Development Application and Planning Proposal Review NSW Planning Portal Concurrence and Referral

Authority	Authority's Reference	Agency Concurrence and Referral	Authority Contact	Authority Notification	Submission Due	Submission Made
NSW Dept. of Planning, Housing & Infrastructure	SSD-96107226		Media Hakim	12/05/2026	10/06/2026	14/05/2026

Address	Land Title
106 – 228 Aldington Road, Kemps Creek	Lot 200 DP 1285691

Environmental Impact Statement (EIS) for the Lot O - 200 Aldington Road Industrial Estate. Construction and operation of a single temperature-controlled warehouse with ancillary office space.

Drawing Title	SITE PLAN INTERIM ROAD DESIGN
SHEET NUMBER	1250033_A004
ISSUE	0

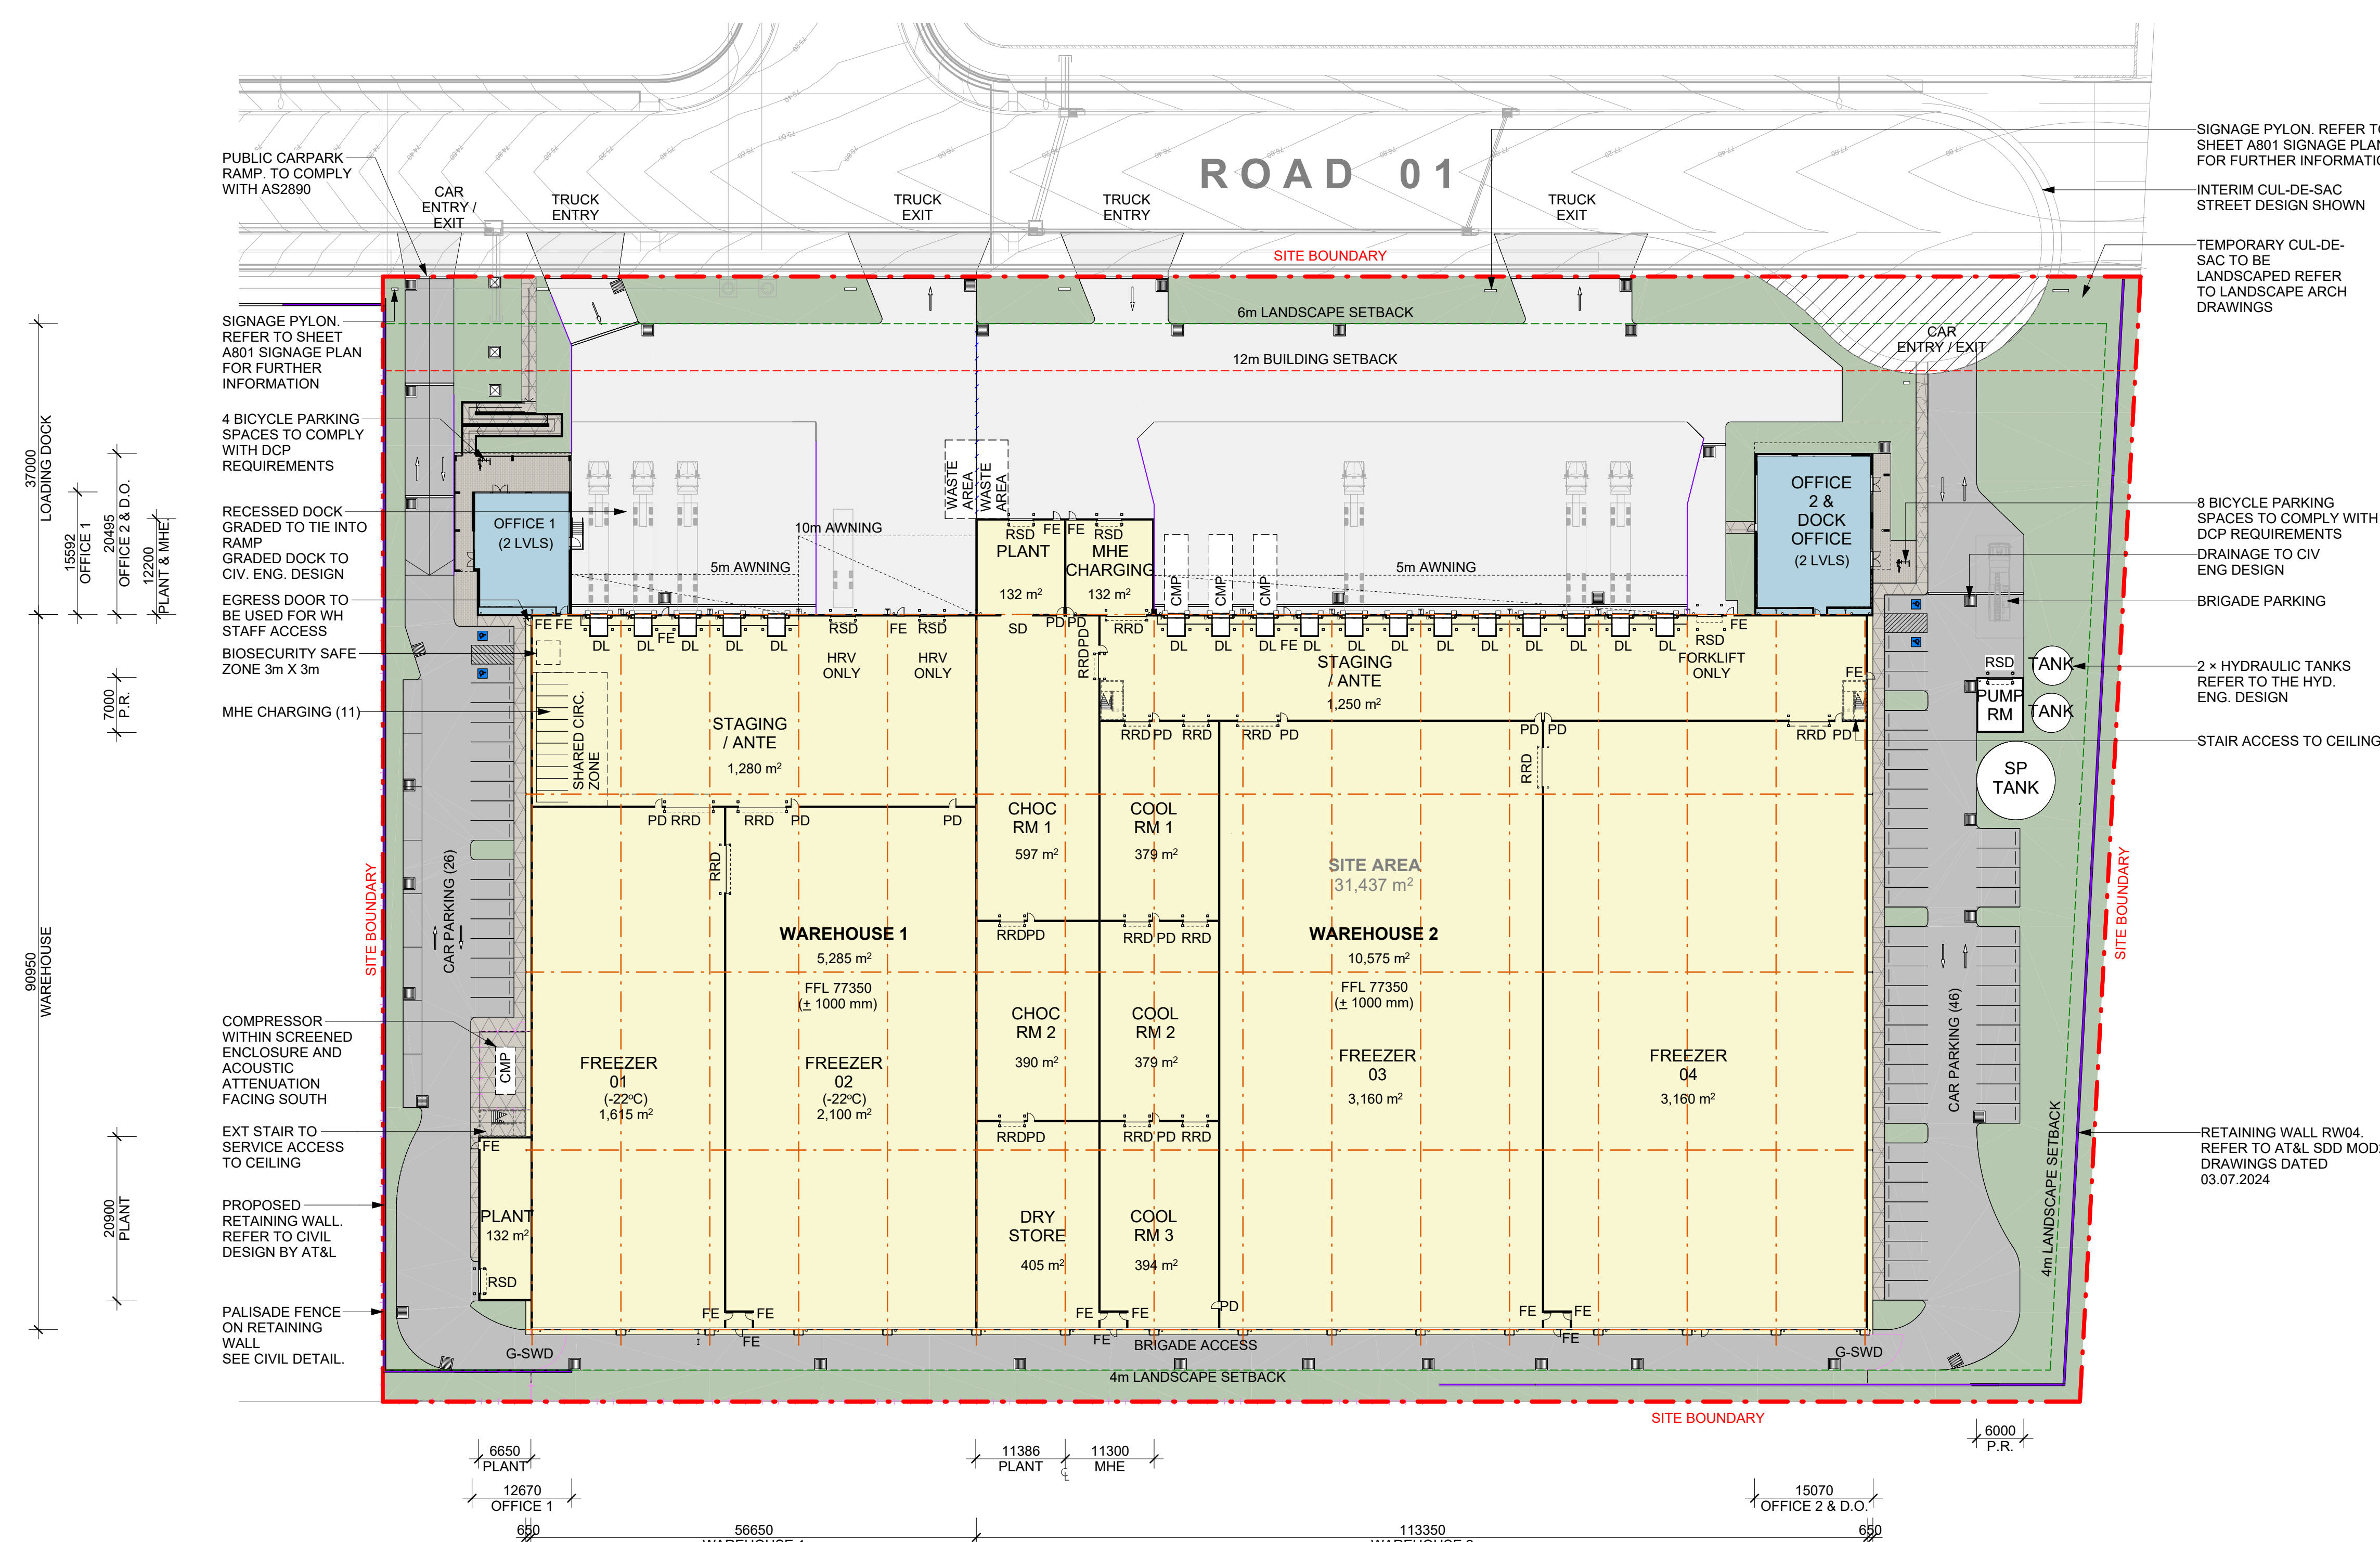
- Any required padmount substation/s will need to be located within the property (in a suitable and accessible location) and be protected (including any associated cabling not located within a public road / reserve) with an appropriate form of property tenure as detailed in the attached copy of Endeavour Energy's 'Land Interest Guidelines for Network Connection'.

The below copy of the Site Plan Interim Road Design does not appear to show provision for any padmount substation/s on the site.
